Re: **DEL TACO**
1500 Gibson Blvd SE
Traffic Circulation Layout
Architect's Stamp 10-12-2021 (L15-D049)

Based upon the information provided in your submittal received 11-12-2021, the above referenced plan cannot be approved for Building Permit until the following comments are addressed:

SITE DETAIL SHEET

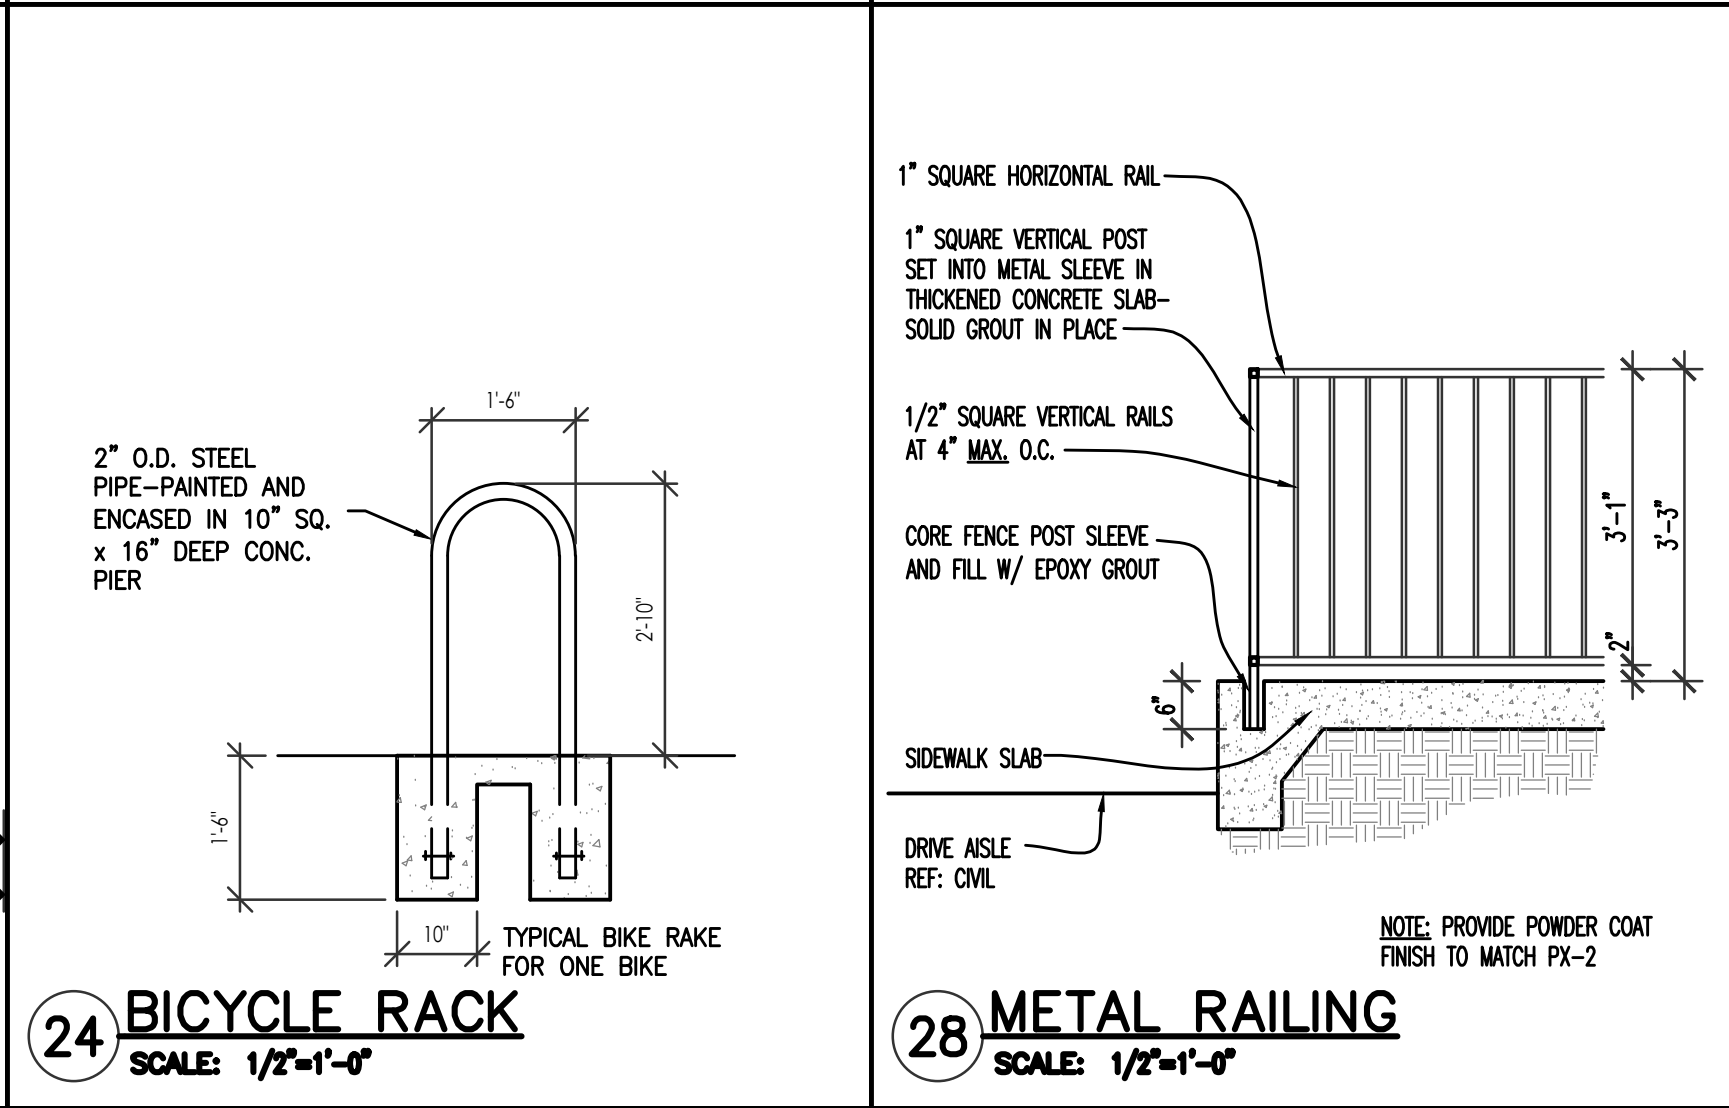
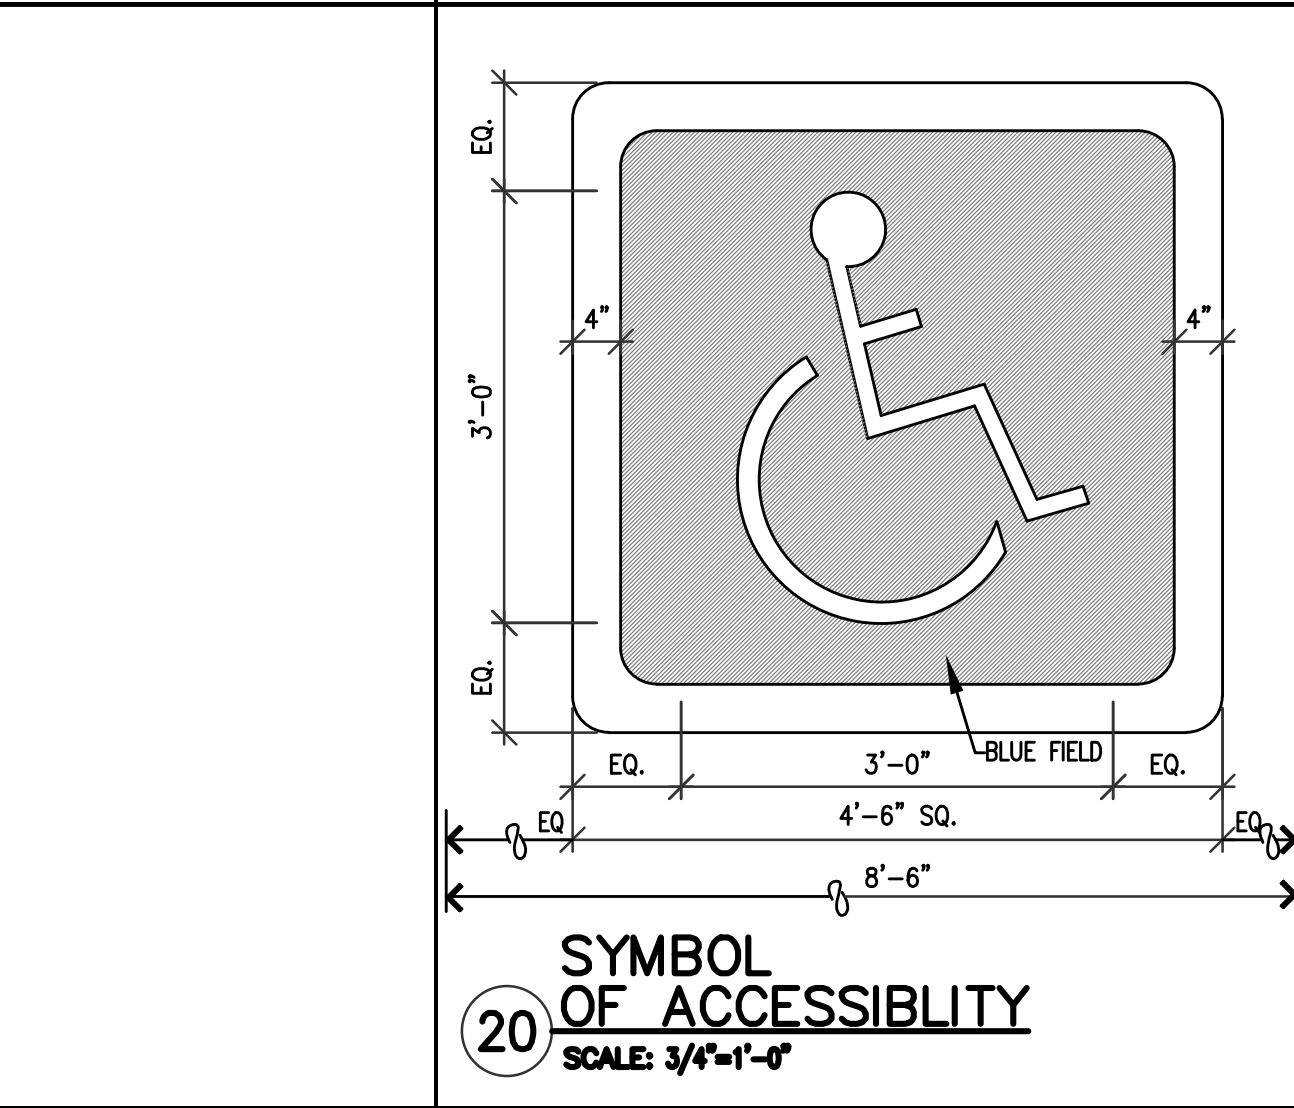
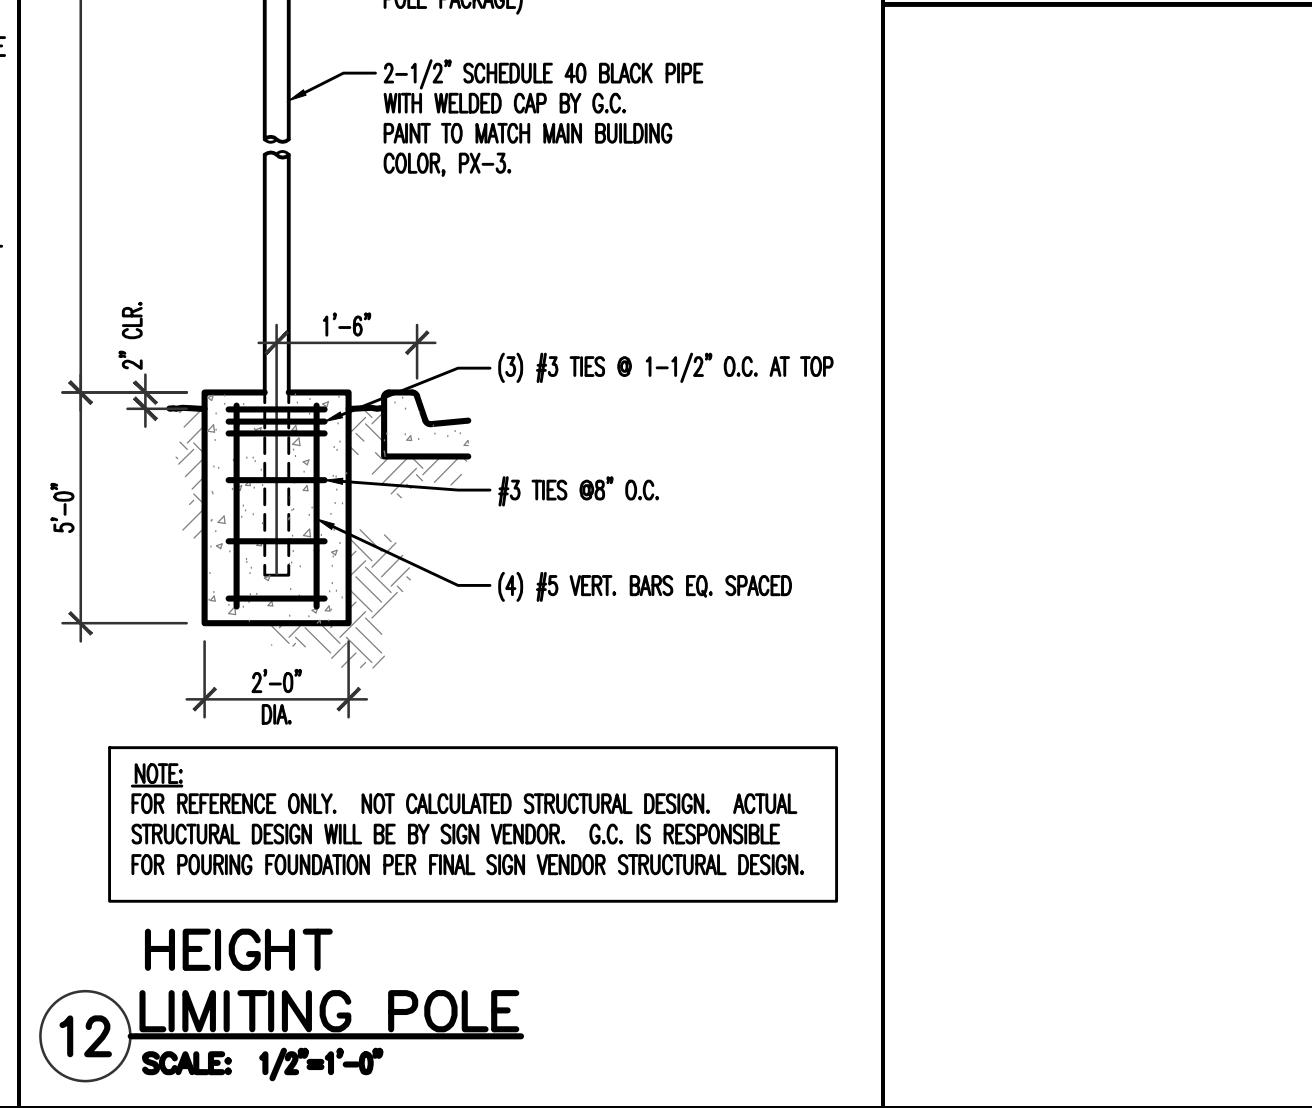
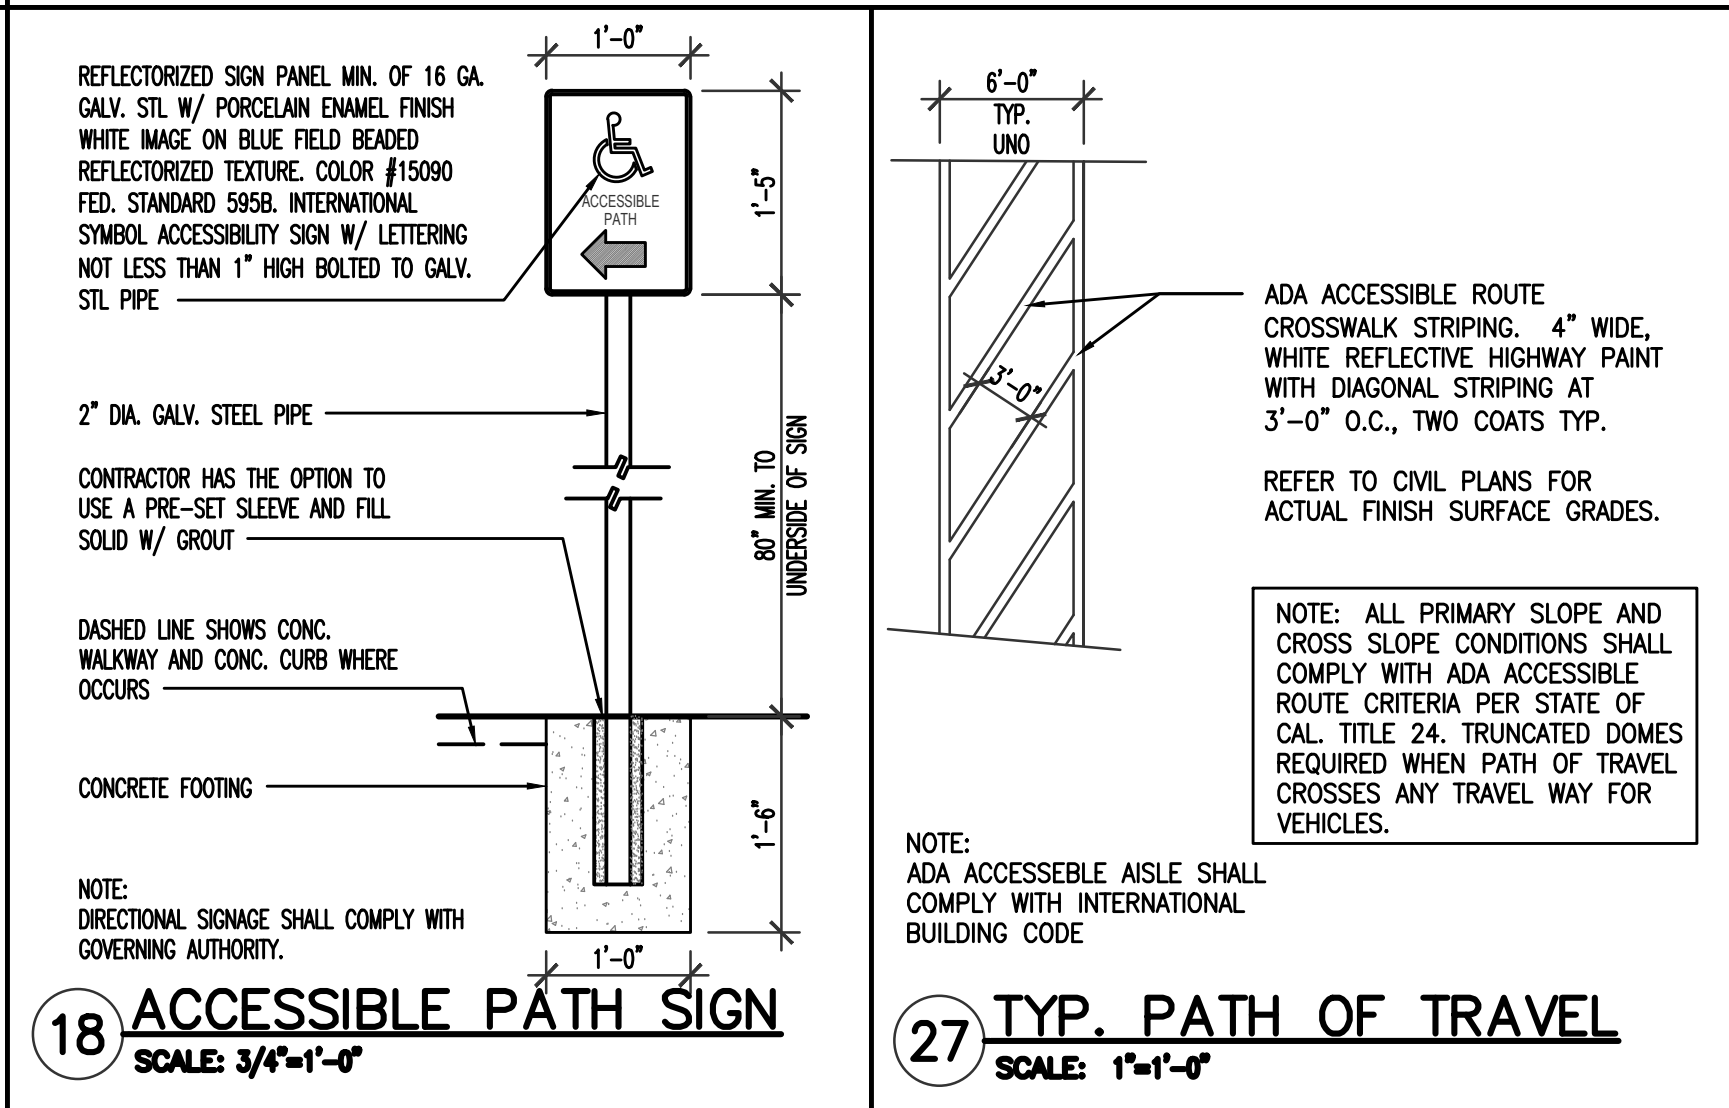
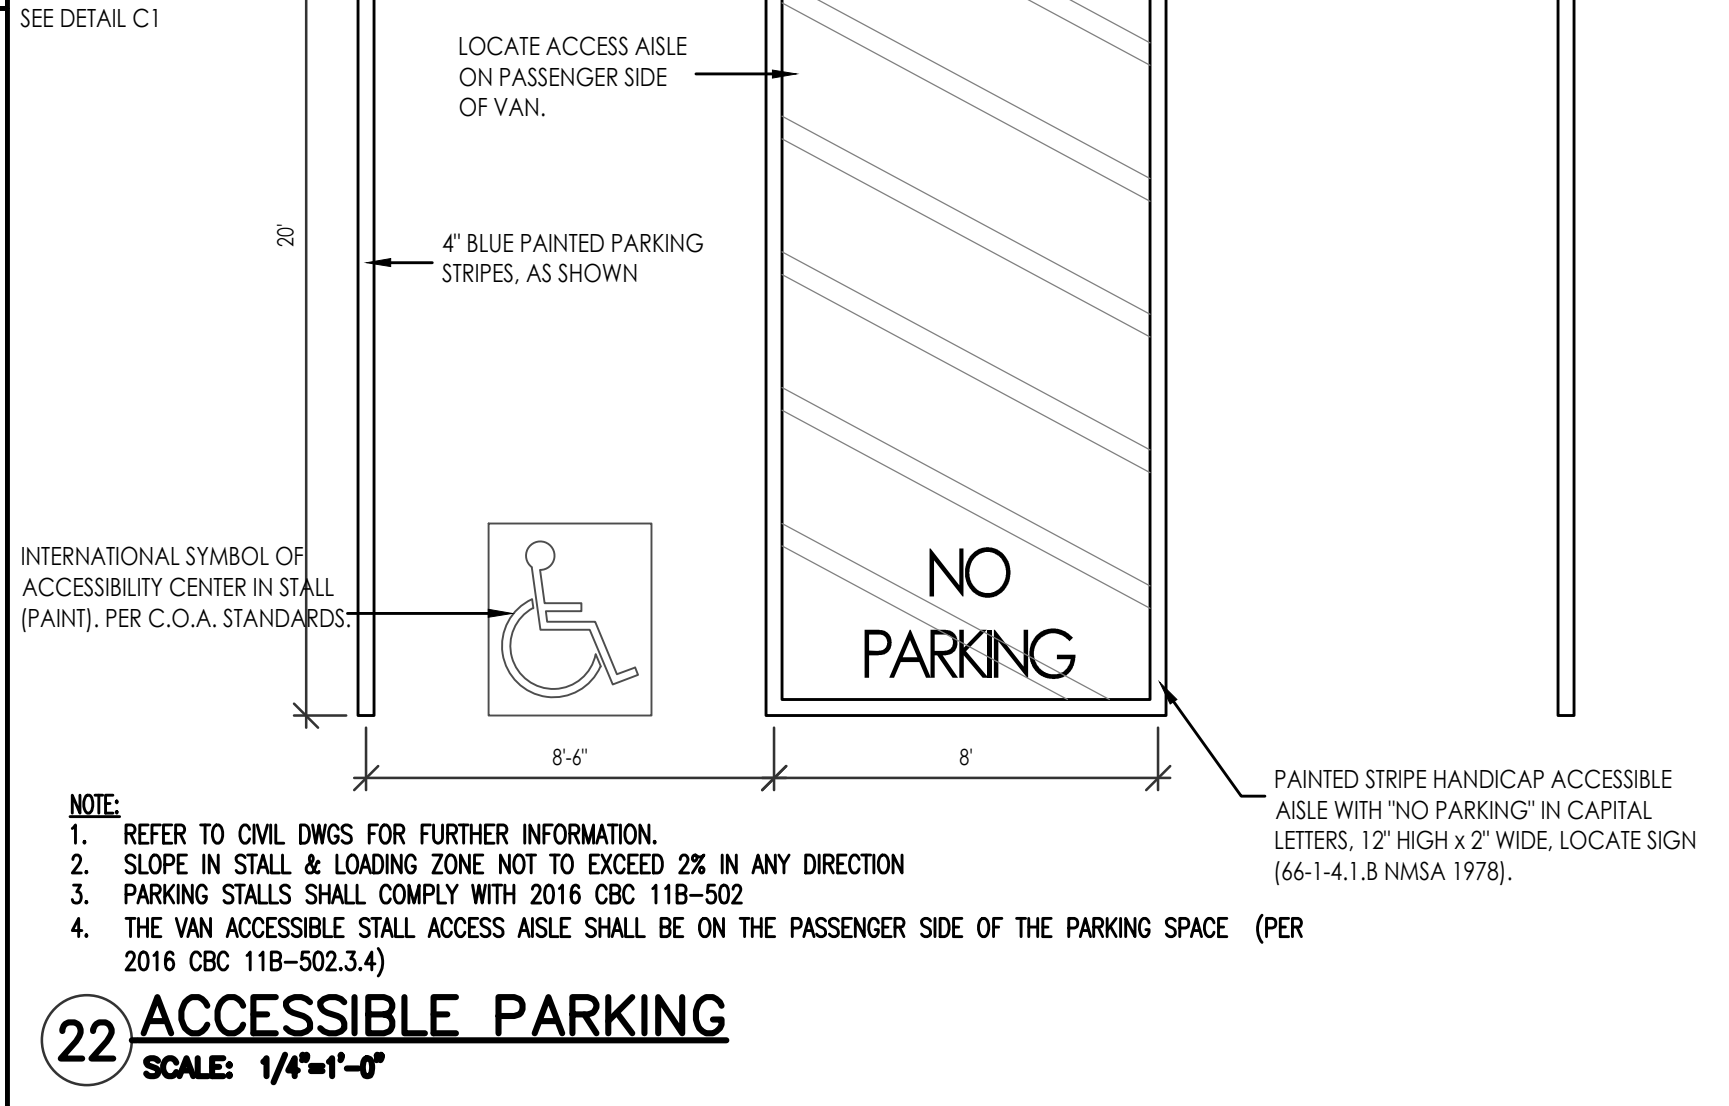
1. Provide existing and proposed sidewalk width.
2. All proposed pavement markings will need to have details provide
3. Keyed Note 2: Provide the size of proposed c&g (6") since there are several on COA std dwg 2415A.

4. Keyed Note 10 Accessible Ramp: Recommended referencing COA std dwg 2444, especially for the accessible ramps in front of the building entrance.
5. Keyed Note 27 & 36: provide signage's face details.

6. Keyed Note 16: please add not (proposed sign will need to be located on private property which includes air space.
7. Identify all existing access easements and rights of way width dimensions (If applicable).

8. ADA curb ramps must be updated to current standards and have truncated domes installed. Verify that existing Gibson Blvd. driveway entrance ramps are in compliance

9. Provide dimension for Motorcycle parking space.
10. List radii for all curves shown; for passenger vehicles (minimum radius per DPM 15 ft). Radius for delivery trucks, fire trucks, etc. is 25 ft. or larger.

11. Per the IDO, a 6 ft. wide ADA accessible pedestrian pathway is required from the public sidewalk to the building entrances. Please clearly show this pathway and provide details.

12. Per DPM, a 6 ft. wide ADA accessible pedestrian pathway is required from the ADA parking stall access aisles to the building entrances. Please clearly show this pathway and provide details.

13. ADA accessible pedestrian pathway should not be placed behind parking space or adjacent to a vehicular way. Vehicle and pedestrian/wheel chair conflicts should be avoided as much as possible. This is concerning the ADA parking stall access aisle across the main circulation drive aisle

14. Parking areas shall have barriers to prevent vehicles from extending over public sidewalk, public right-of-way, or landscaping.
15. ADA parking stall signage and 2 ft overhang is in conflict. Please clear up.

16. Provide details for "Do Not Enter" signage.
17. **The minimum drive through lane width is 12 feet with a 25 foot minimum radius (inside edge) for all turns. (A 15 foot radius can be used with an increase in lane width to 14 feet). Please dimension all lane widths and radii.**

18. Please provide a sight distance line (SSD) exhibit.
19. Please specify the City Standard Drawing Number when applicable.
20. Shared Site access: driveways that straddle property lines, or are entirely on one property but are to be used by another property, shall have an access easement. Please include a copy of your shared access agreement with the adjacent property owner.

21. Add a note stating "All broken or cracked sidewalk must be replaced with sidewalk and curb & gutter." A build note must be provided referring to the appropriate City Standard drawing (2430 & 2415A). This is the correct note and should be replaced on keyed note 22.
